WEST SUSSEX COUNTY COUNCIL CONSULTATION

TO:	Arun District Council FAO: Zac Denton
FROM:	WSCC - Highways Authority
DATE:	17 February 2020
LOCATION:	Land to the rear of 43 Sea Road, East Preston, Littlehampton, BN16 1JN
SUBJECT:	EP/160/19/PL Demolish redundant external store and former outside toilet at rear of 43 Sea Road and construct a single storey extension to create a 2 bedroom apartment.
DATE OF SITE VISIT:	n/a
RECOMMENDATION:	Advice
S106 CONTRIBUTION TOTAL:	n/a

GROUND FLOOR PLAN 1:100 @ A3 / 1:50 @ A1

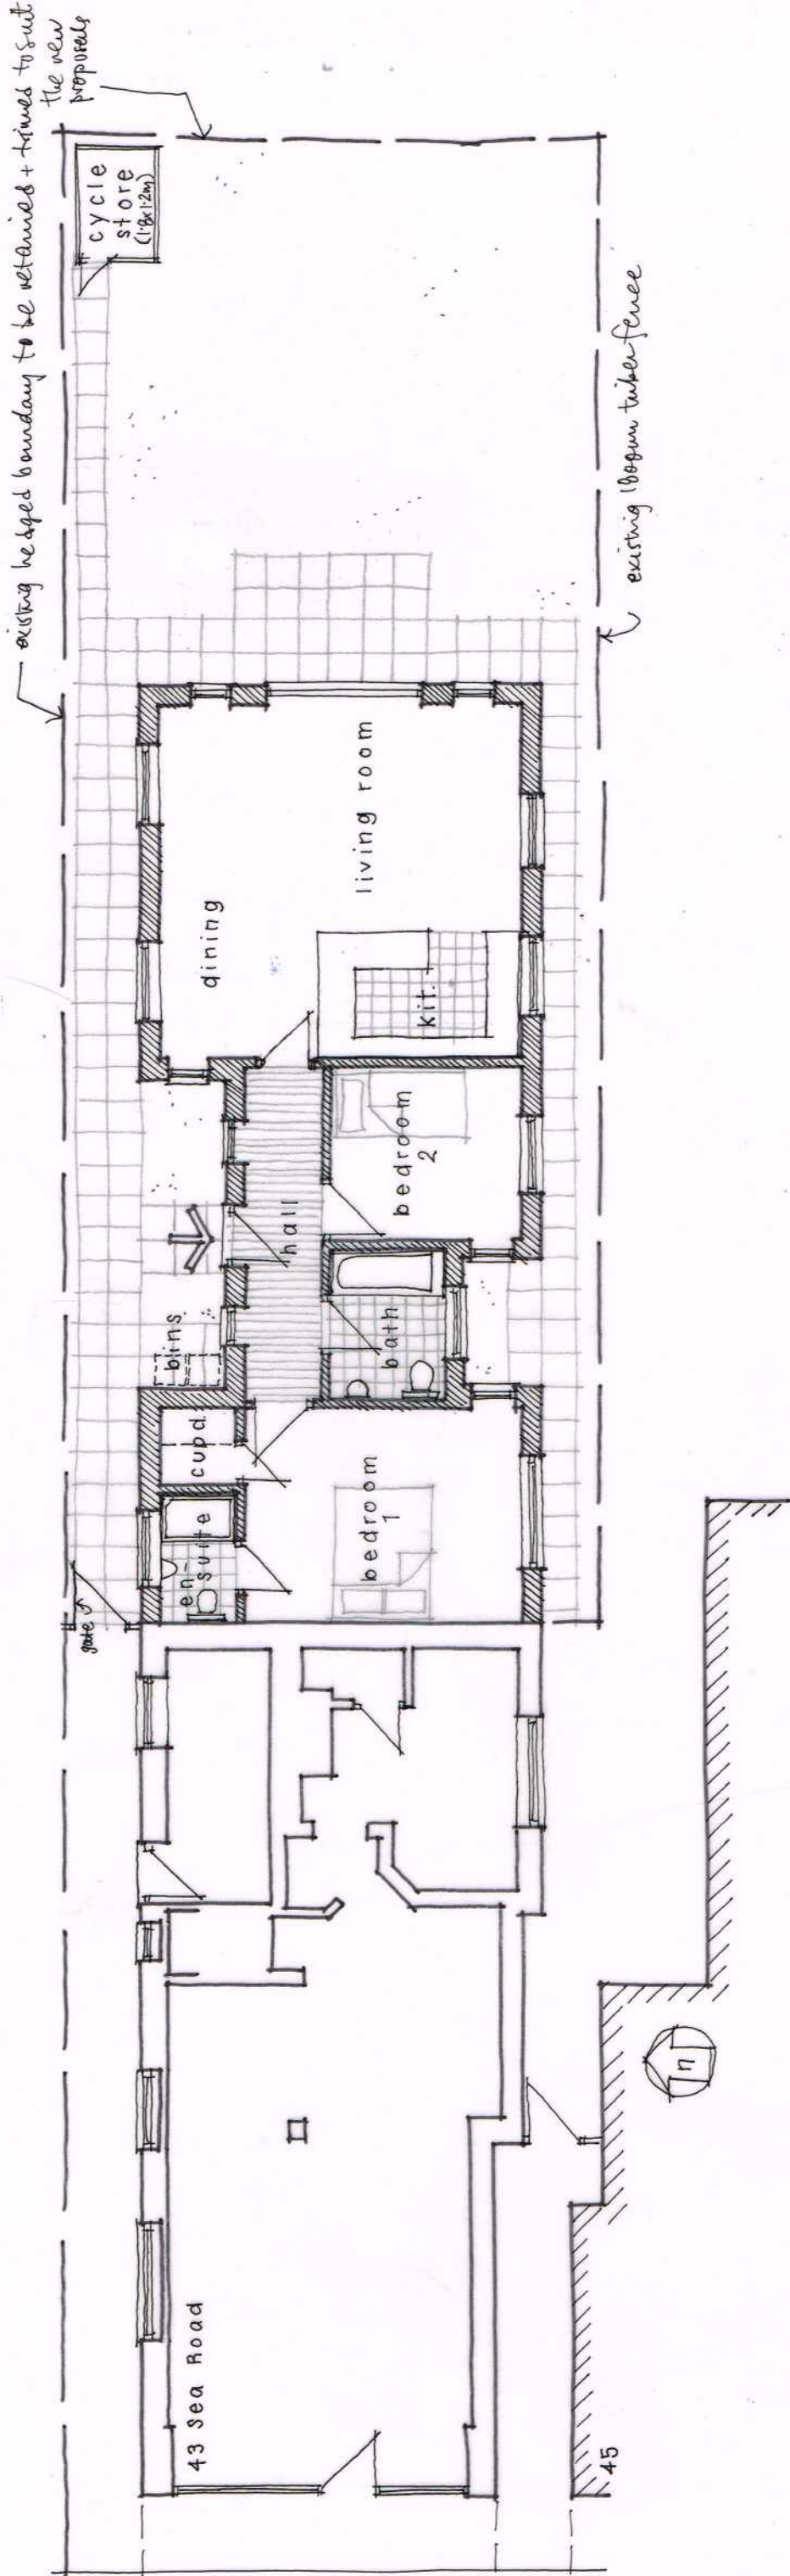
The site is sustainably located within walking distance of a variety of local shops and services, and bus stops providing access to surrounding areas, including Brighton, Littlehampton and Chichester. Cycling is a viable option within the vicinity and the proposed plans demonstrate secure and covered cycle storage for the dwelling.

No part of the development shall be first occupied until covered and secure cycle parking spaces have been provided in accordance with the approved plans.
